**Transport
for NSW**

Exhibition of Modification Request for Barangaroo Headland Park and Northern Cove Main Works, Barangaroo (MP 10_0048 MOD 8) - Demolition of Harbour Control Tower

CD16/02926

7 APPENDIX A – TRAFFIC ROUTES

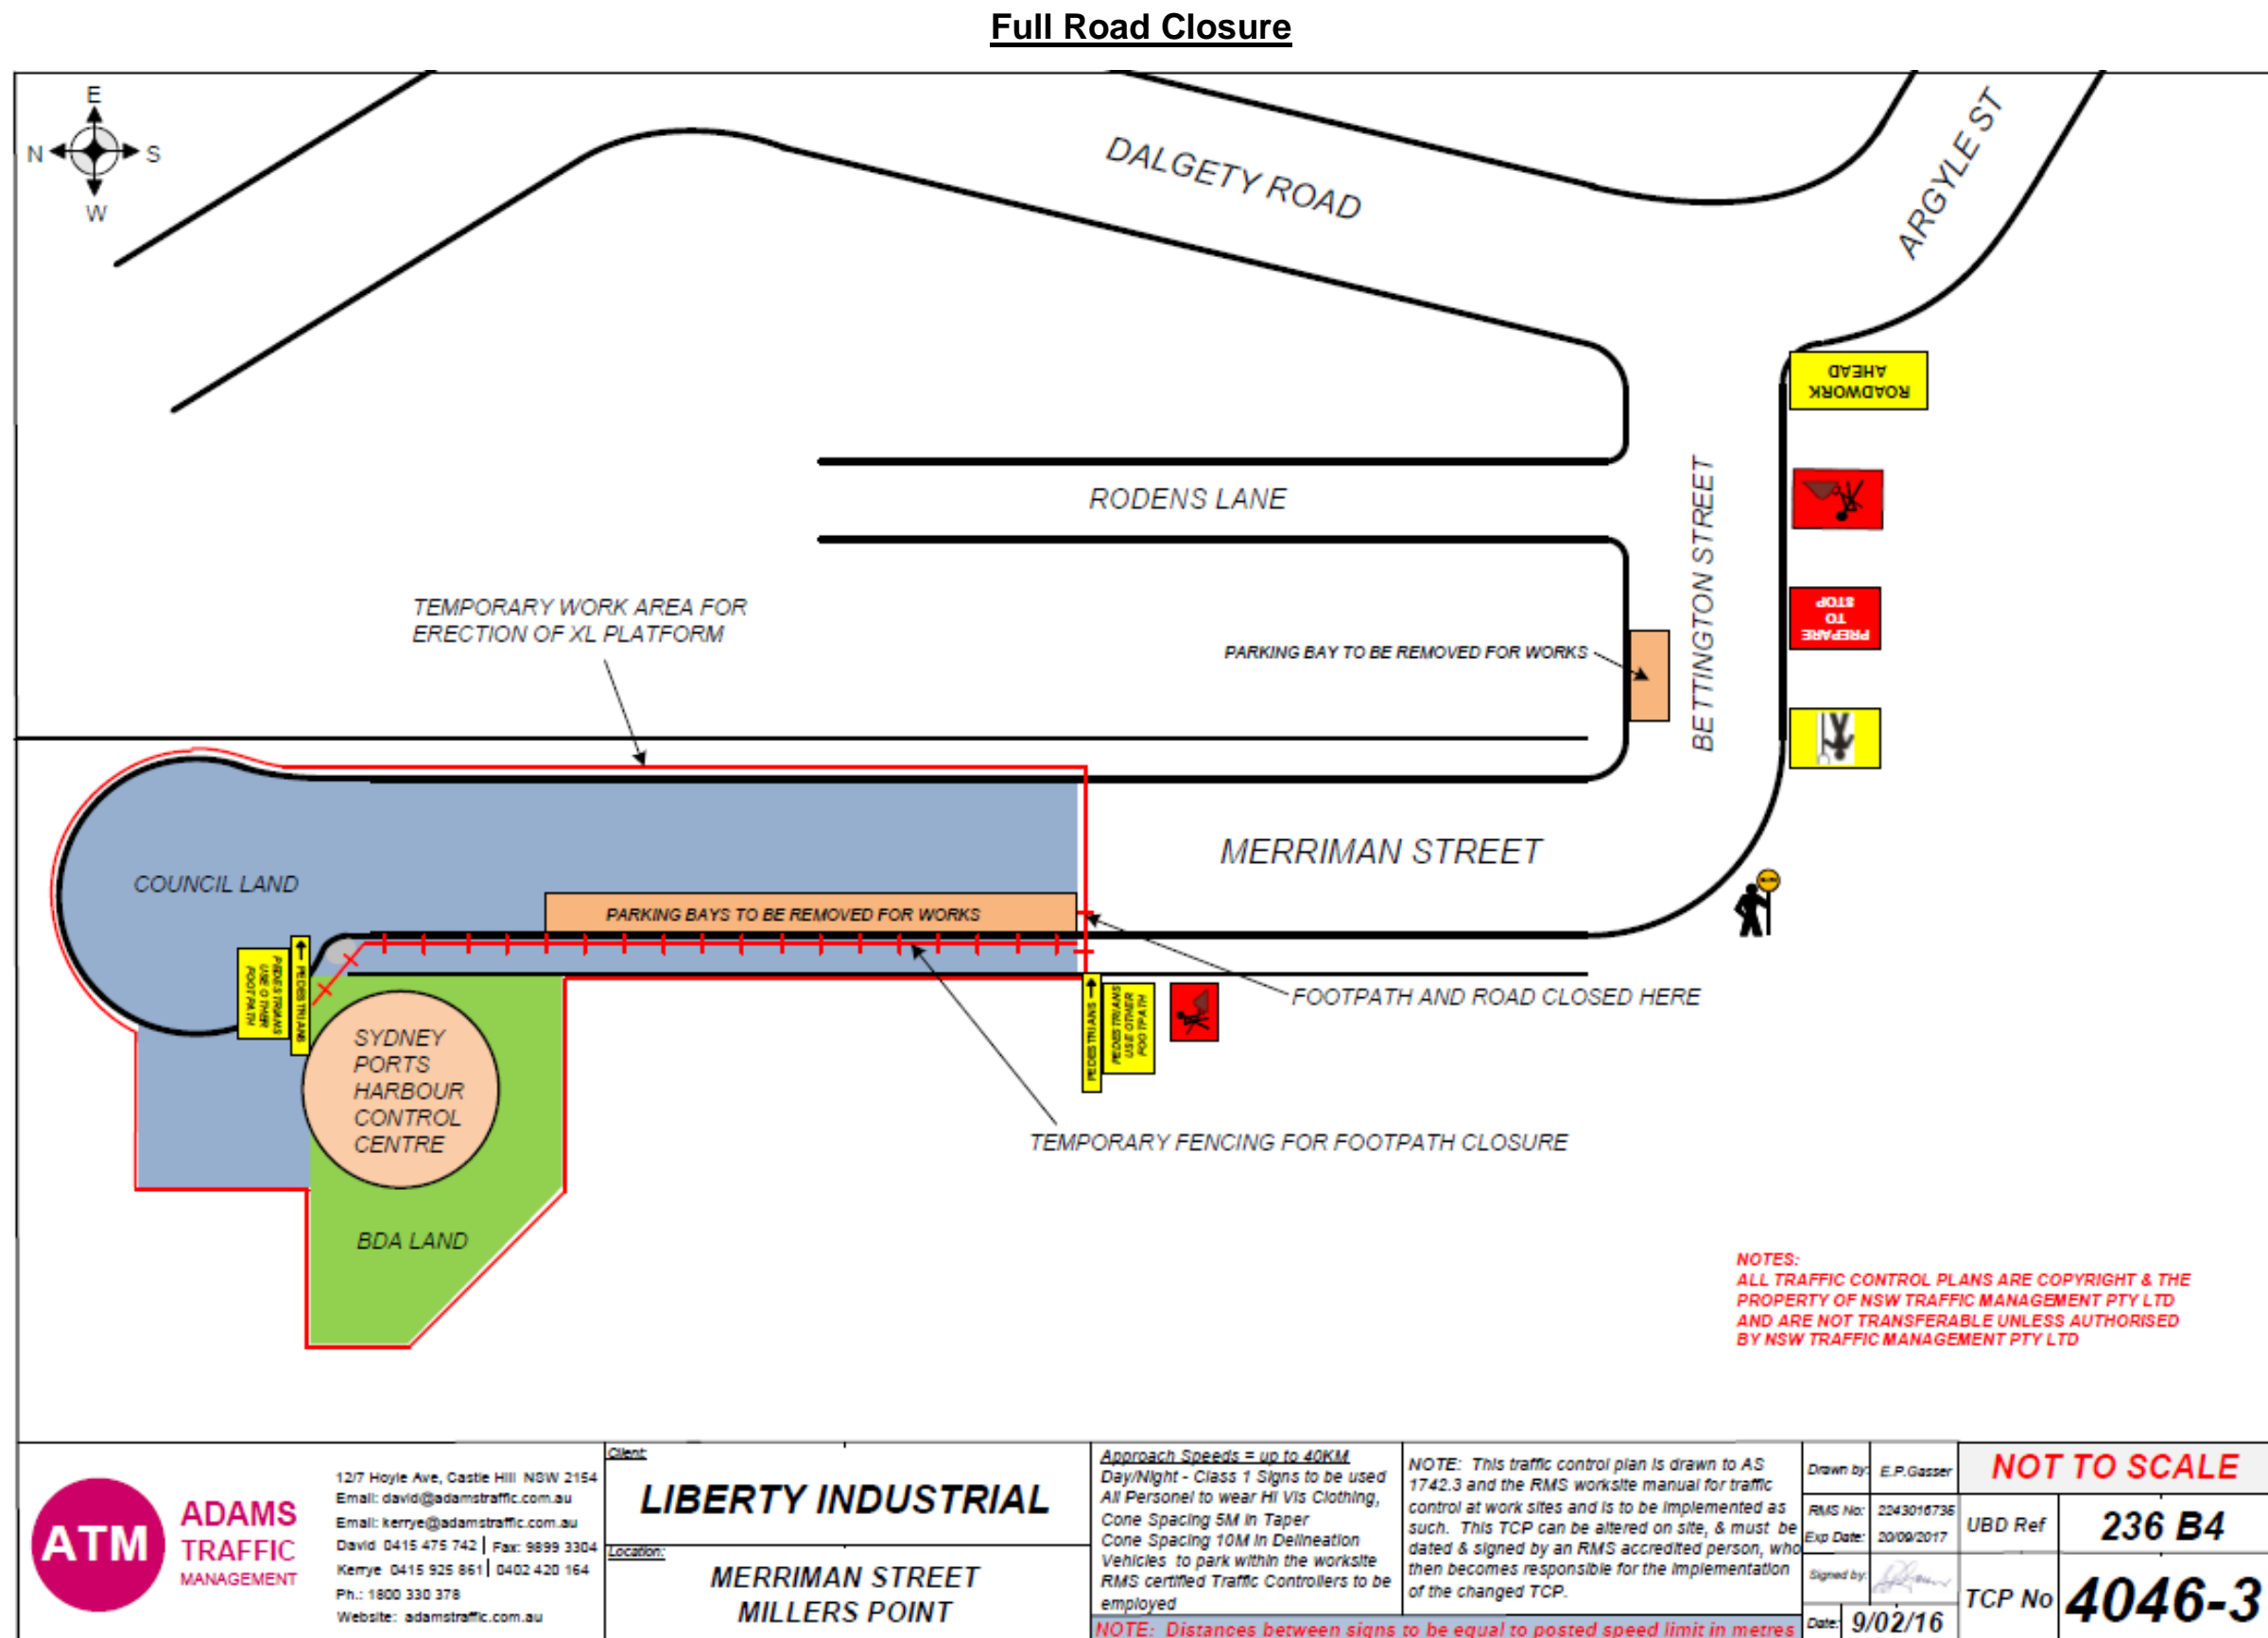
Harbour Control Tower Demolition Works – Traffic Management Plan prepared by Liberty Industrial Pty Ltd has not included detailed information in relation to traffic, pedestrians and cyclists impact and the management of these impacts.

- Haulage route for vehicles accessing Merriman Street;
- Location of the loading dock in the cut-away;
- Estimated number and type of construction vehicle movements for all stages of work, including construction workers accessing the site, during peak periods and throughout the day;
- Swept path analysis for all construction vehicles into and out of Merriman Street and the cut-away;
- Proposed construction hours;
- Detailed assessment of the safety of Headland Park users during the demolition of the Harbour Control Tower;
- Construction program for each stage of the work;
- Details of the red light/ green light system that is proposed as a pedestrian safety measure for the cut-away exit for construction vehicles;
- Details of proposed measures for local residents accessing Merriman Street during the closure of Merriman Street;

TfNSW requests that the Traffic Management Plan be updated in consultation with the CBD Coordination Office within TfNSW and Roads and Maritime Services. The CTMP needs to specify, but not limited to, the following:

8 APPENDIX B – PROPOSED TCP'S FOR MERRIMAN ST CLOSURES

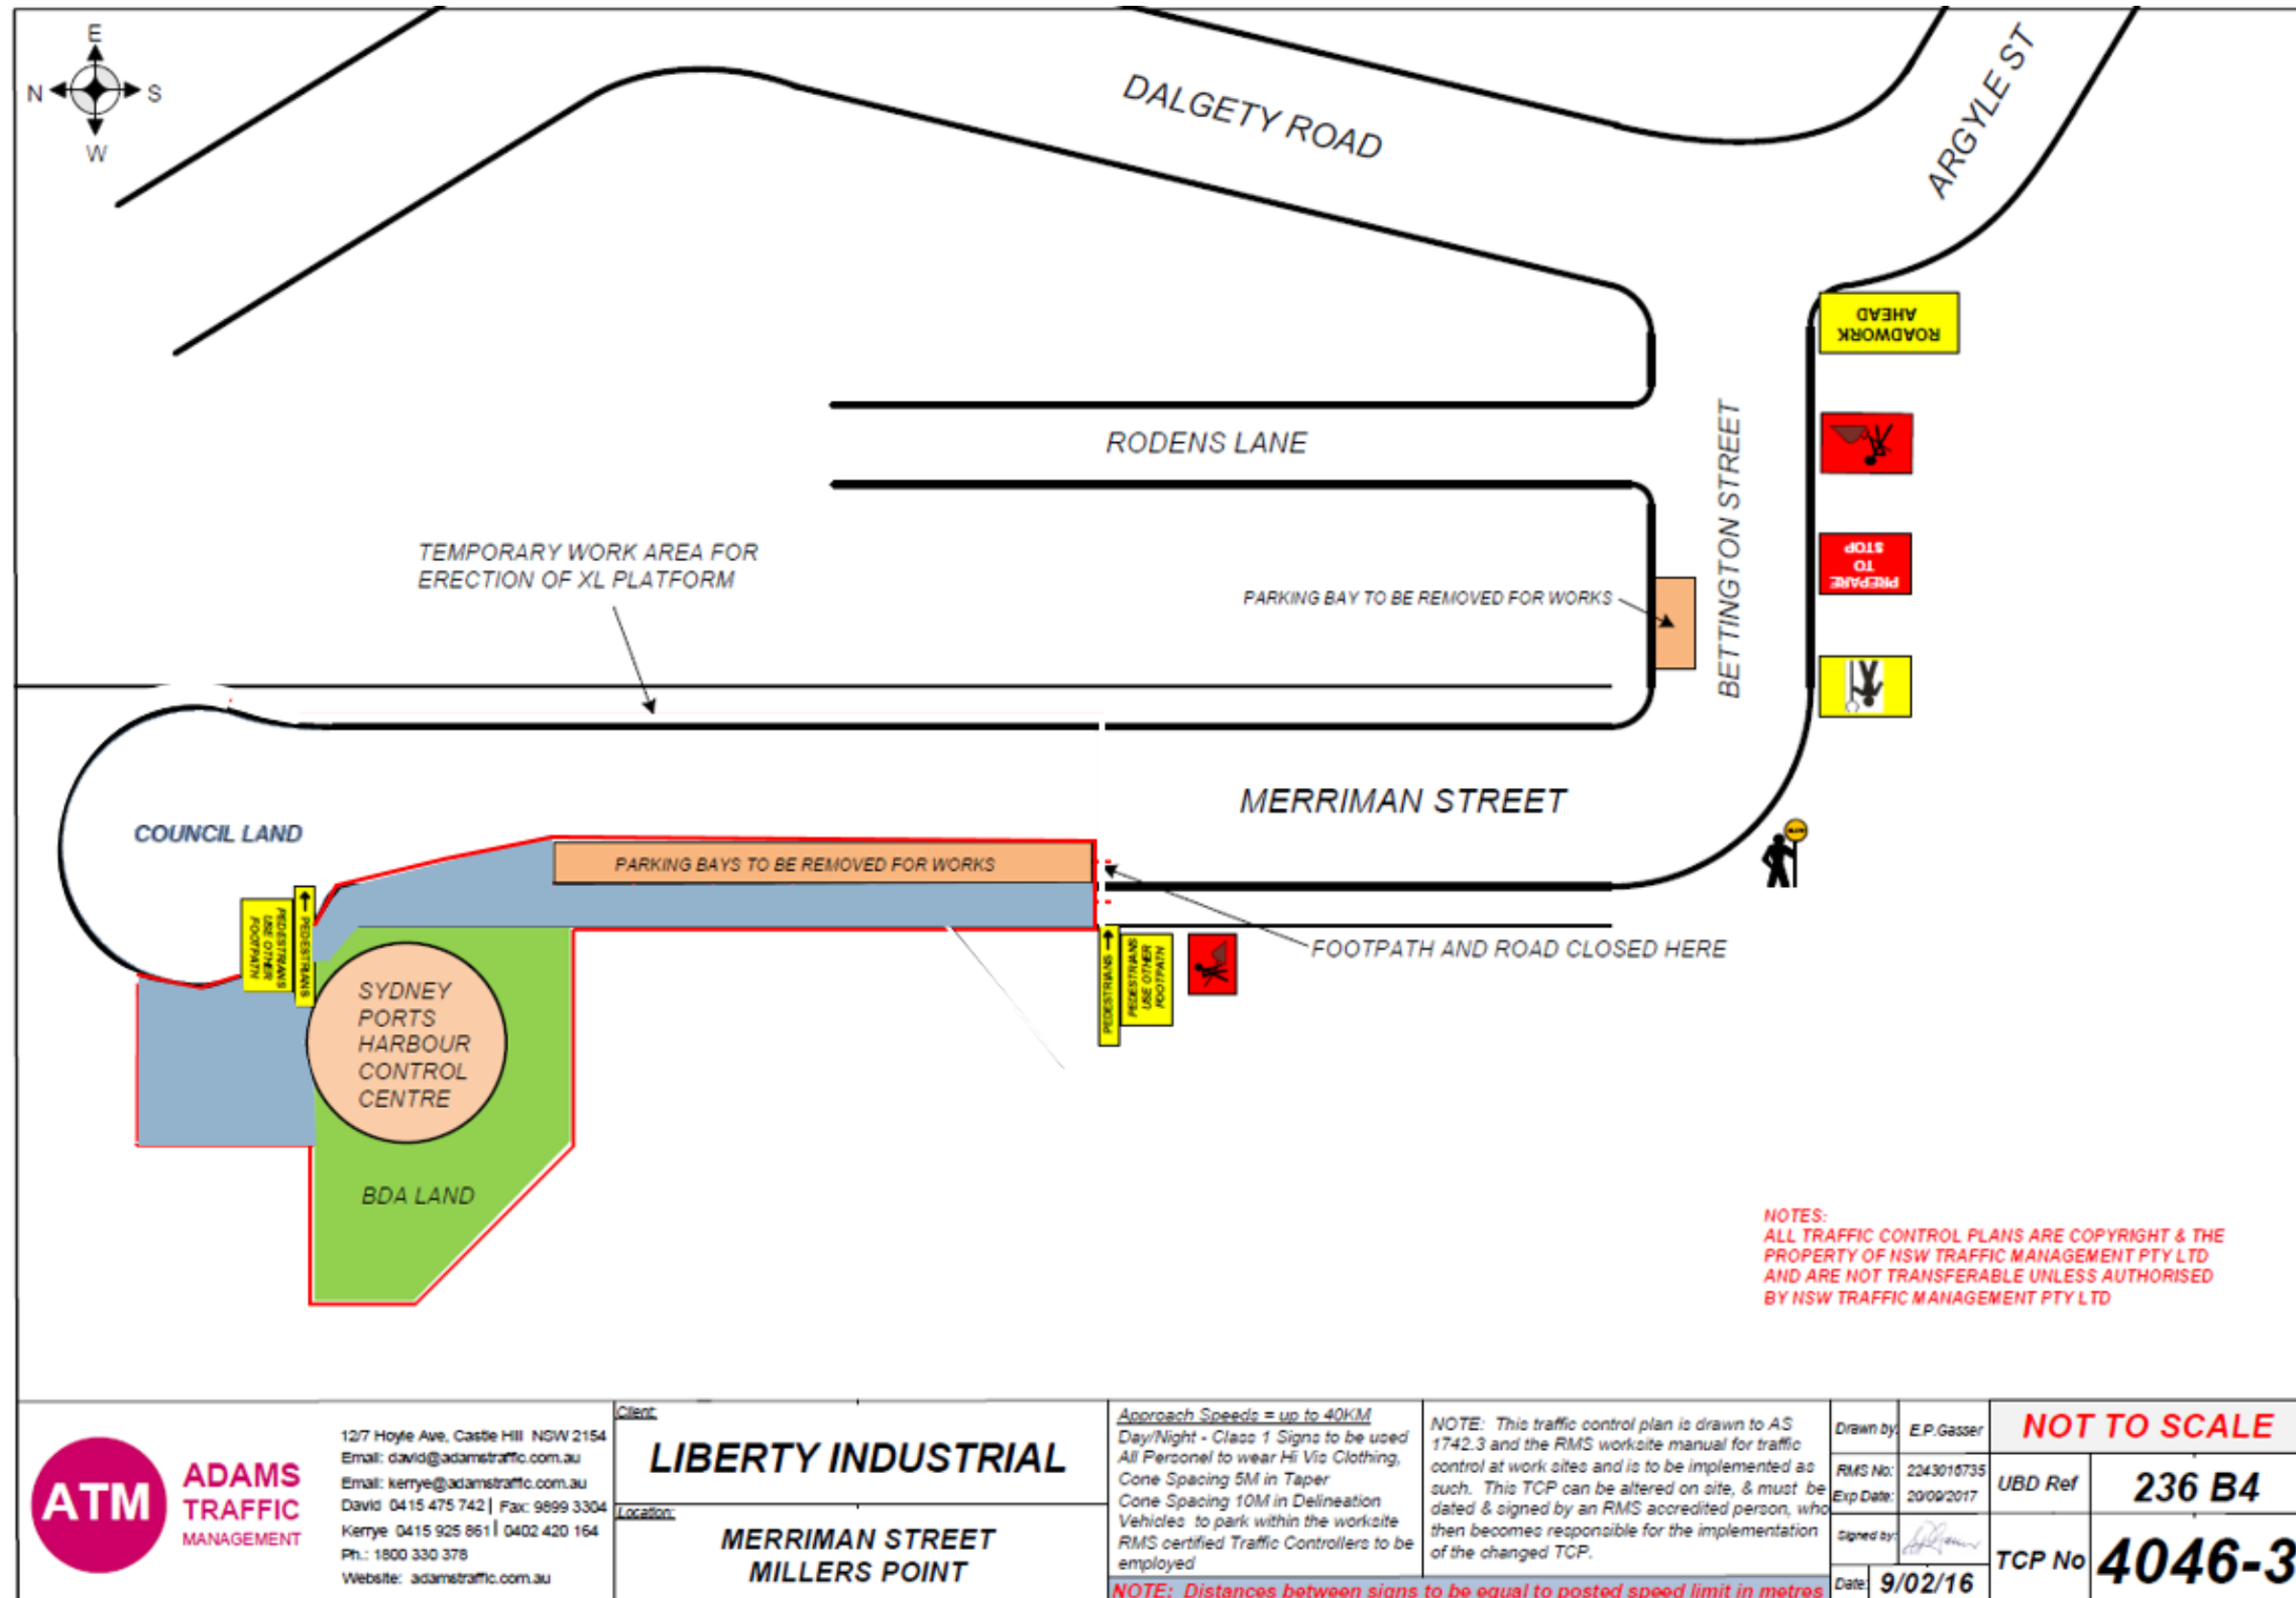
The proposed construction activities include partial and full closure of Merriman Street. It is not clear from the CTMP that a road occupancy licence will be obtained for these closures.

TfNSW advises that a Road Occupancy Licence (ROL) must be obtained from the Transport Management Centre (TMC) for any activity likely to impact on the operational efficiency of the road network. The ROL allows the applicant to use a specified road space at approved times, provided certain conditions are met.

Proponents must allow a minimum of 10 working days for processing from date of receipt. Traffic Control Plans are to accompany each ROL application.
